From: Michael Eastham <Michael.Eastham@arun.gov.uk>
Sent: 16 April 2020 07:14
To: Planning.Responses <Planning.Responses@arun.gov.uk>
Subject: BN/37/20/DOC - The Lillies

From: Alison Meeus [REDACTED]
Sent: 15 April 2020 17:26
To: Michael Eastham <Michael.Eastham@arun.gov.uk>
Subject: BN-37-20

I am currently looking at this DOC application for a cycle path in relation to a condition which was set by the inspector at appeal.

SCALE	1:500 @ A2	DATE	FEB 2020
DRAWN	CLS	CHK	JGF
DRAWING NO.	17748-BARN-5-512	REV	B
TITLE	YAPTON ROAD BARNHAM		
DETAILS	Footpath Link & Typical Footway Constructon Detail

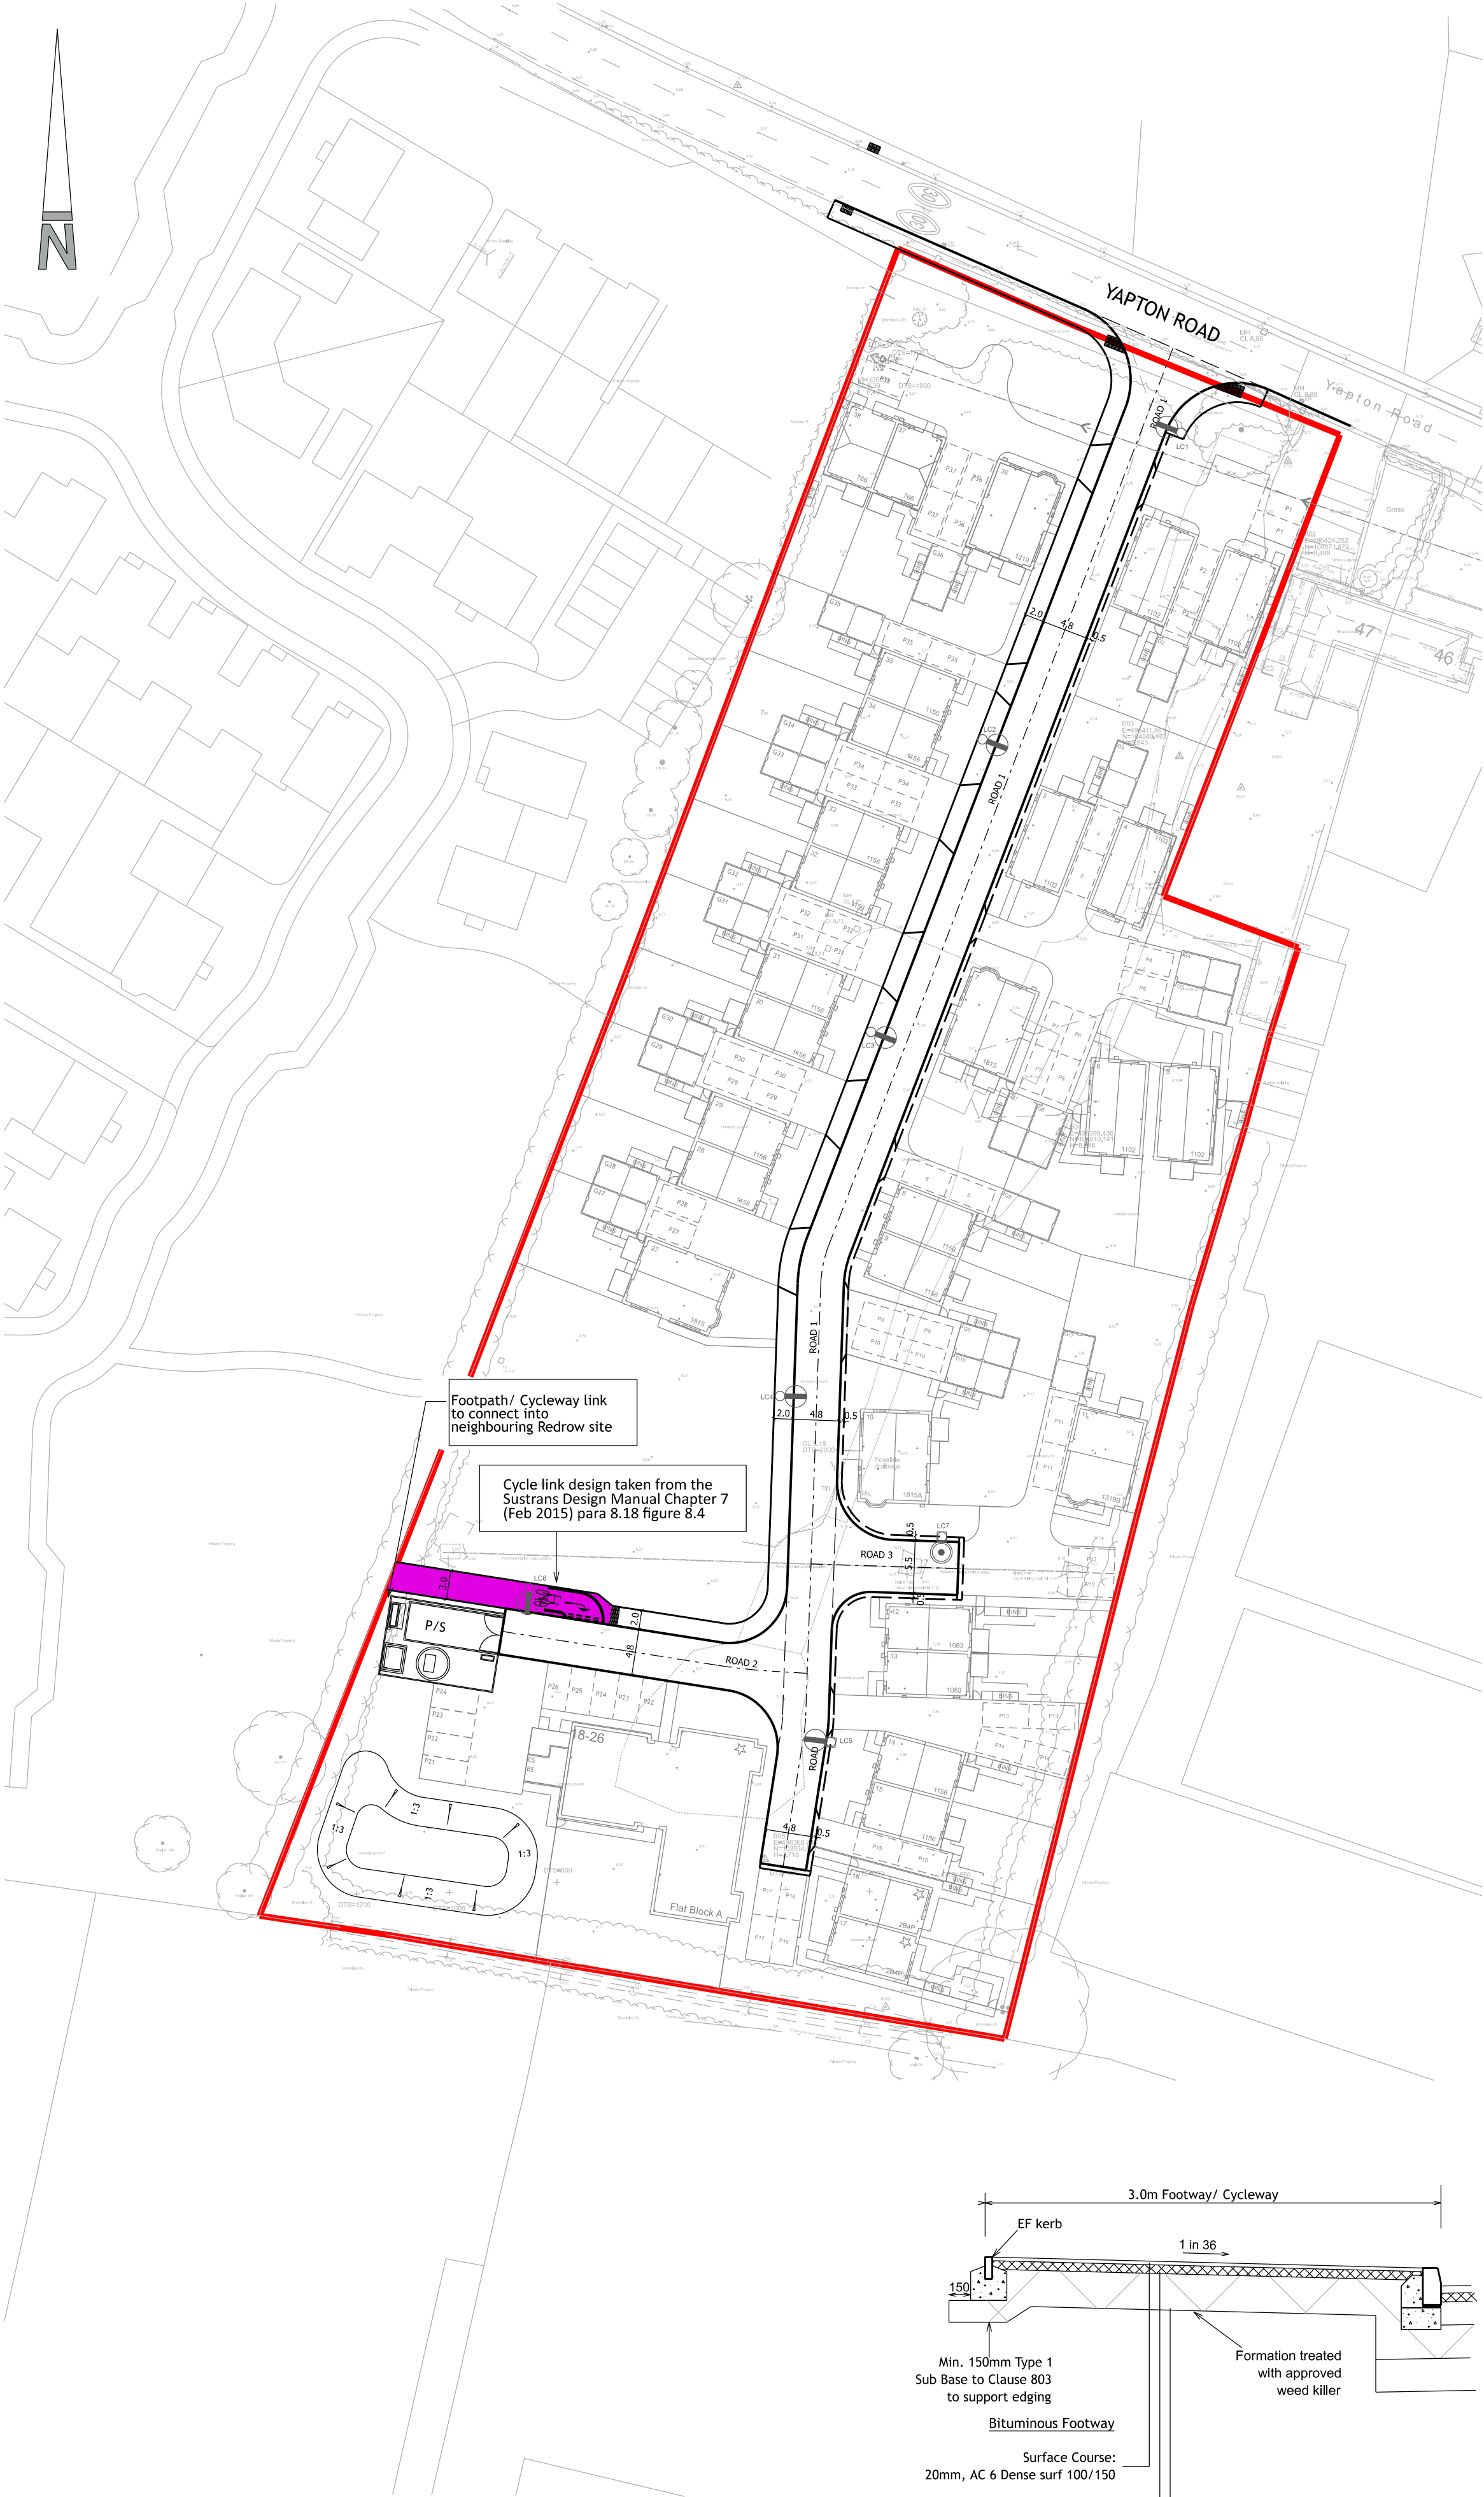
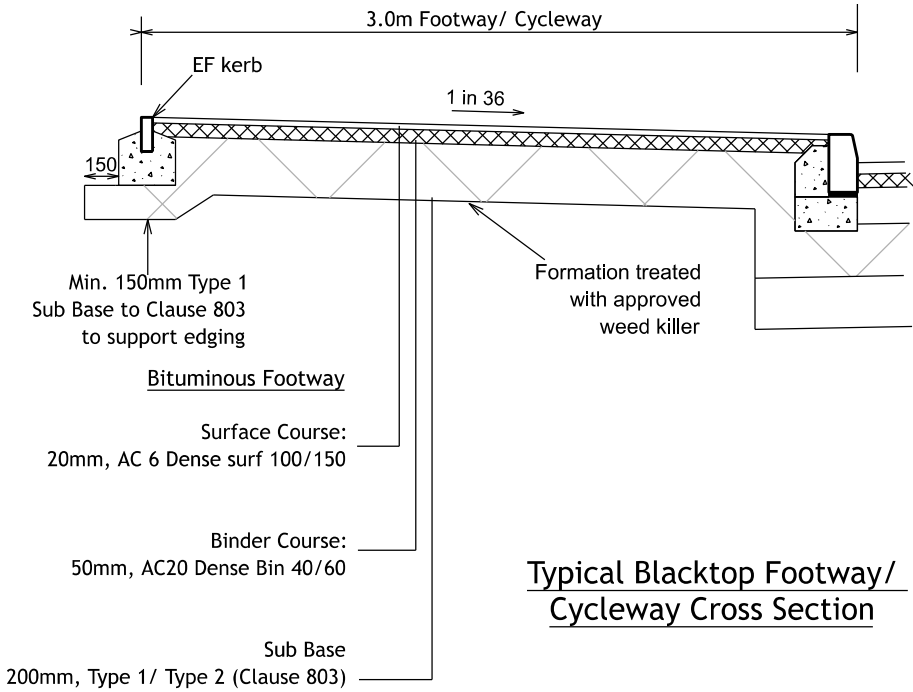
Whilst plans submitted show a cycle path linking the internal site roads of the adjacent housing development (known as angel nursery site) it has been brought to my attention that there should also be a cycle path (3m wide) on the left hand side of the access, linking into the development.

From a planning perspective we would not wish to see an opportunity for encouragement of sustainable travel like this to be missed. Also it is not logical for the path to change from a 3m wide shared use cycle/footpath to a footpath on such a short section of footway. Hopefully you will see the logic, and as such would appreciate it, if you can ask the applicants to revise the drawing to include the extension of a 3m path along yapton road, from the angel nursery side, into the proposed access.

I have also noticed this will need road safety auditing, and will require both a stage 1 and 2 audit, which can be undertaken together to ensure all highway safety issues have been considered.
Therefore until I receive further information I am unable to discharge the condition.
